CITY OF ALBUQUERQUE

March 13, 2018

Re: The Carlisle, 3600 central Ave. SE
Request for Certificate of Occupancy
Transportation Development Final Inspection
Architect's Stamp dated 11-23-15 (K17-D069)
Certification dated 03-05-18

**TCL Plan**  
As Built

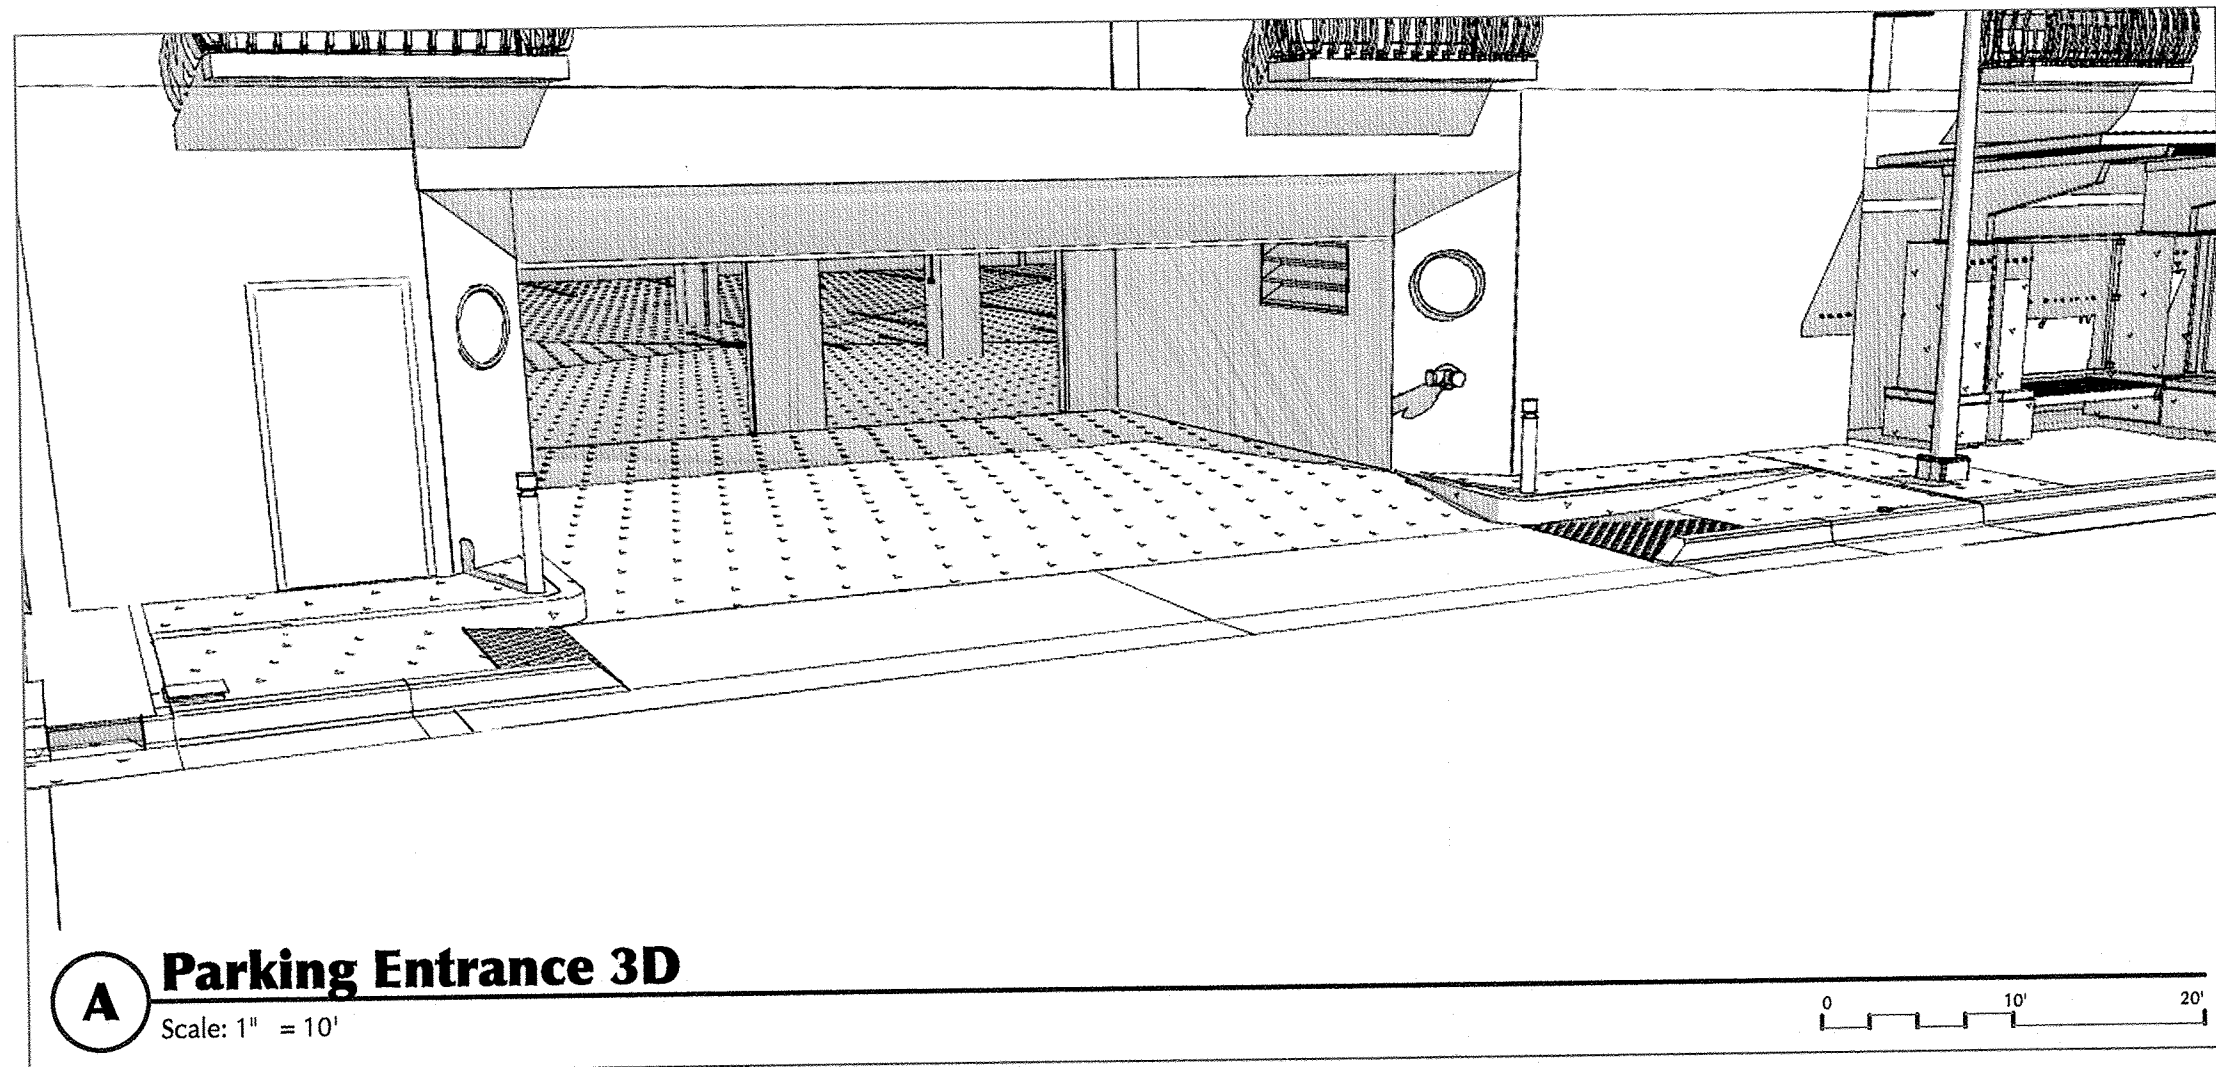
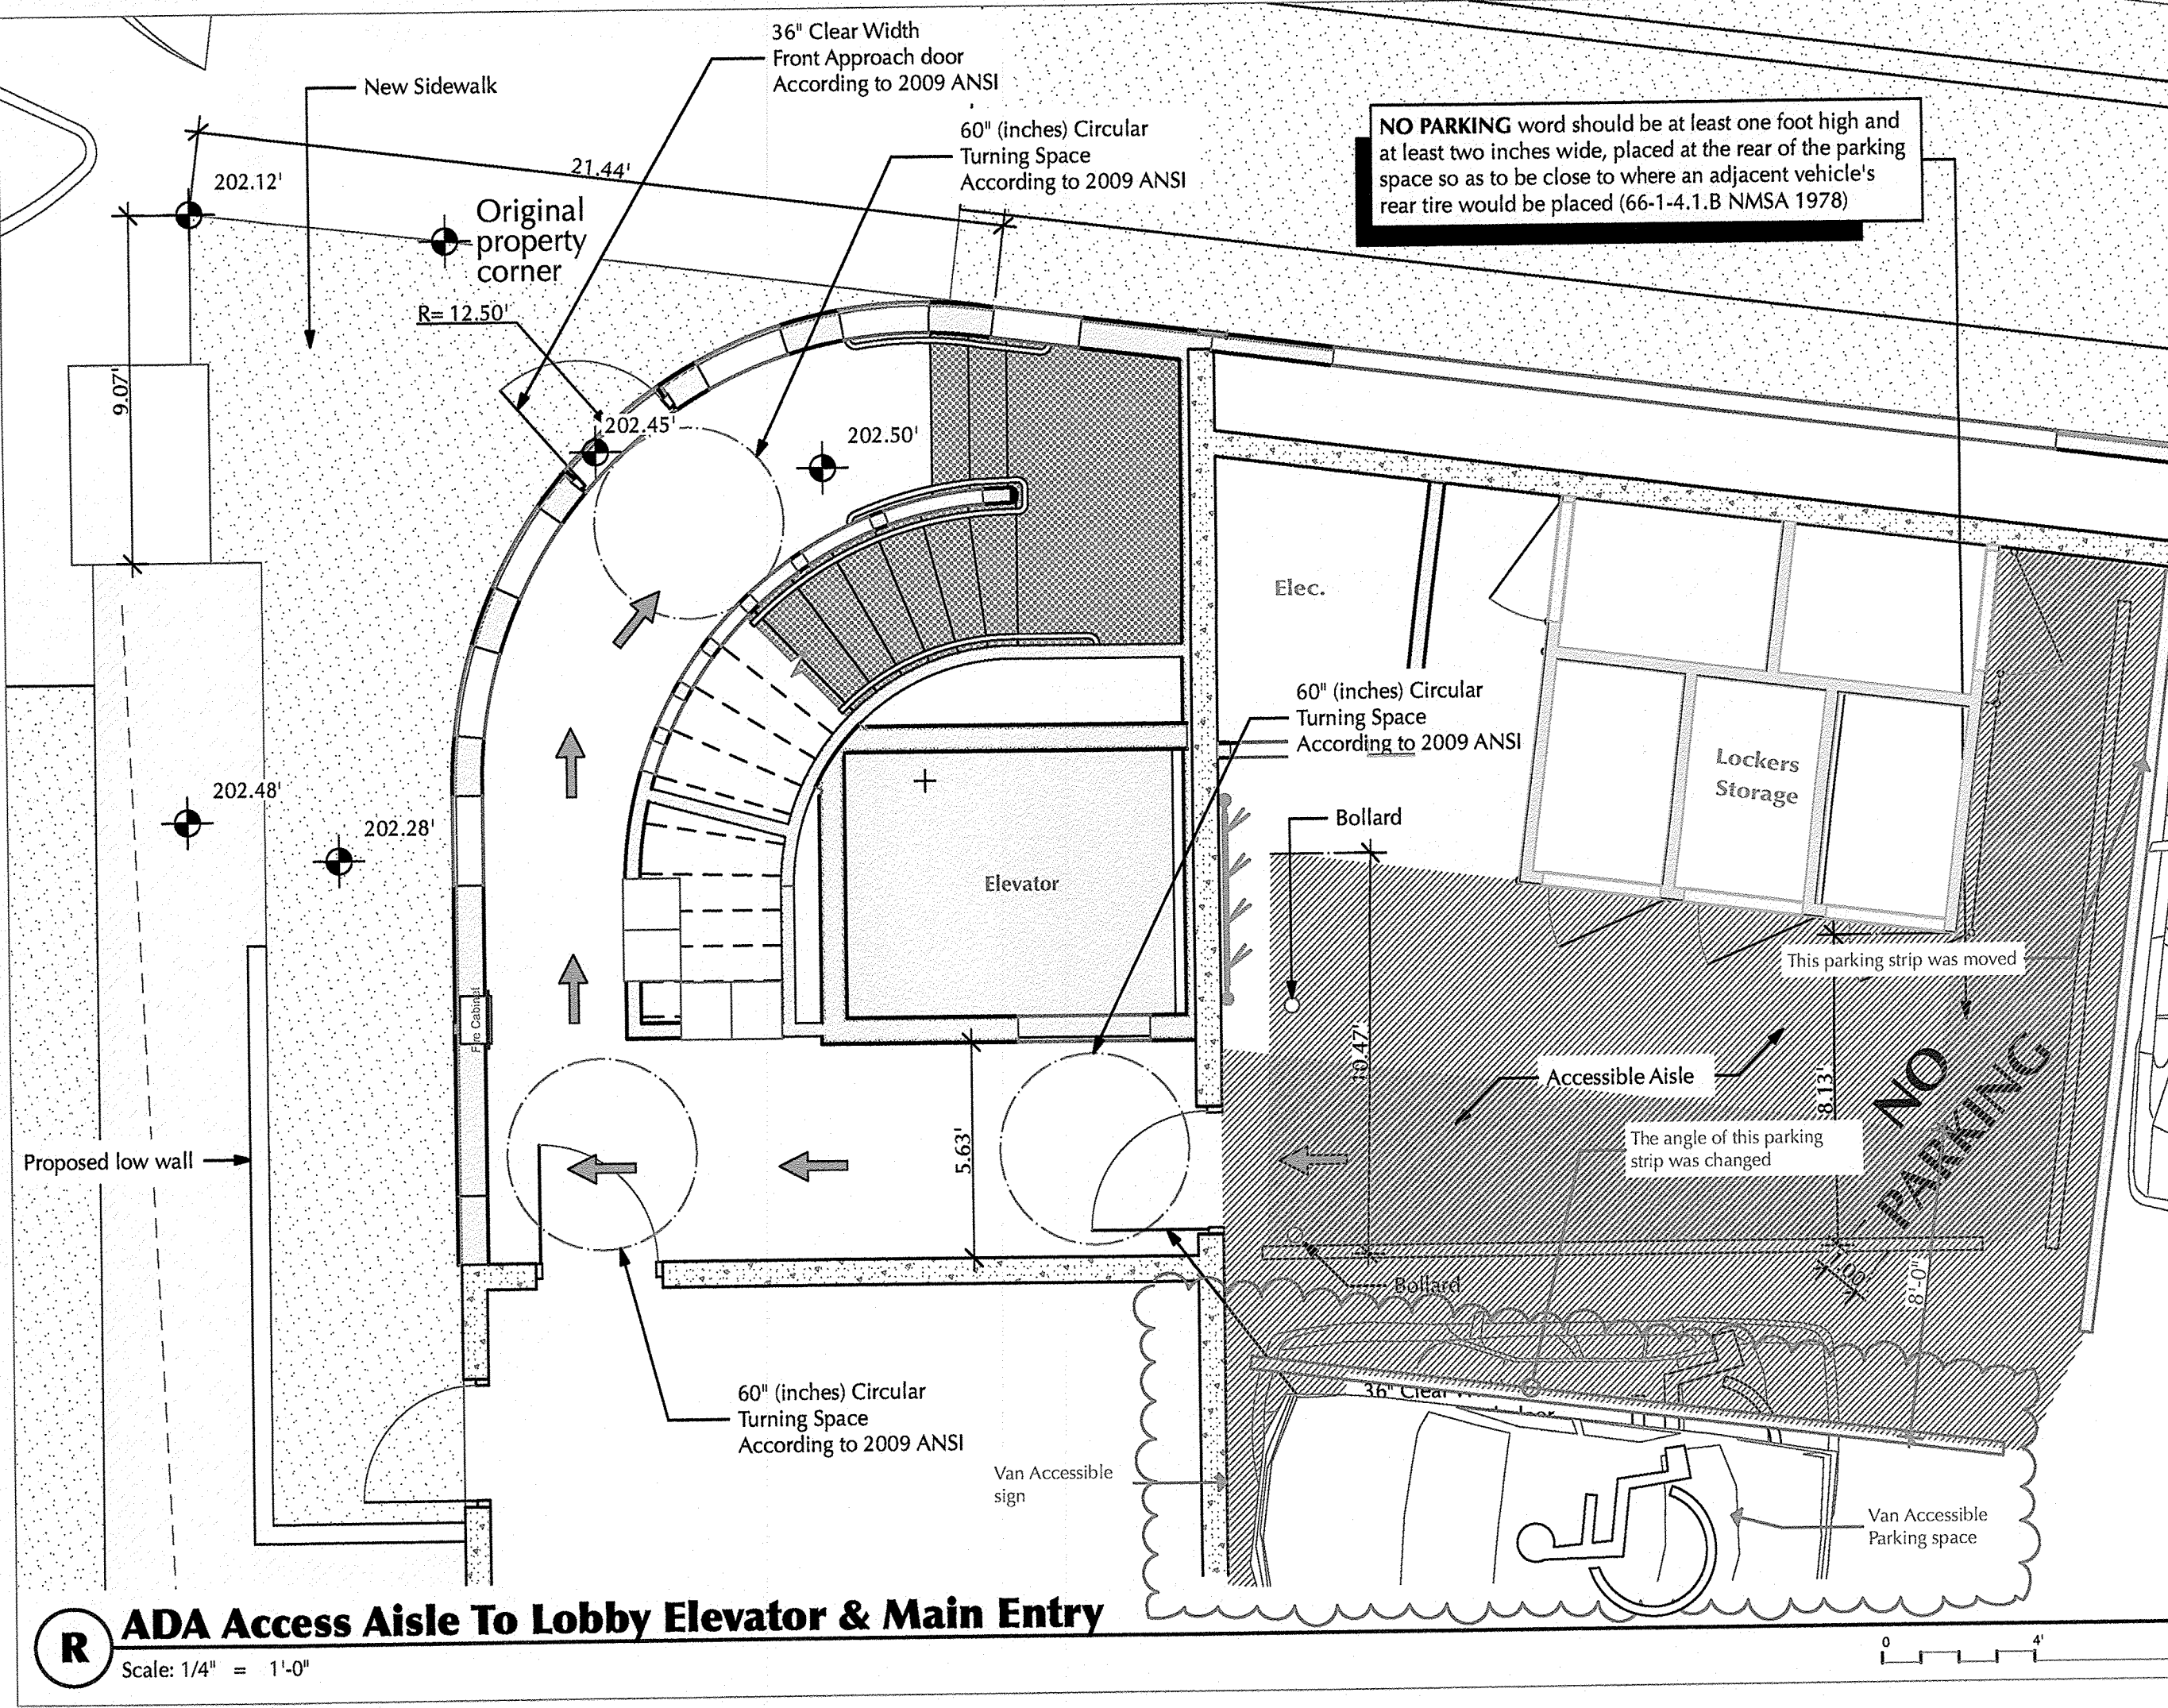
- City Work Order must be closed out and all punch list items completed.
- All construction fencing and equipment must be removed from the site.
- The Van ADA parking spot is missing.

- The ADA access aisles shall have the words **"NO PARKING"** in capital letters, each of which shall be at least one foot high and at least two inches wide, placed at the rear of the parking space so as to be close to where an adjacent vehicle's rear tire would be placed. (66-1-4.1.B NMSA 1978)

- All sidewalk improvements along the property frontage must be completed.
- The public alley must be returned to its original condition.
- The mirrors at the entrance/exit must be adjusted to prevent vehicular pedestrian conflicts.

- The "slow watch for pedestrian" signs are not installed.
- You may want to add a sign indicating the height of the garage doors.
- Additional comments may follow after next submittal when a proper final inspection can be done.
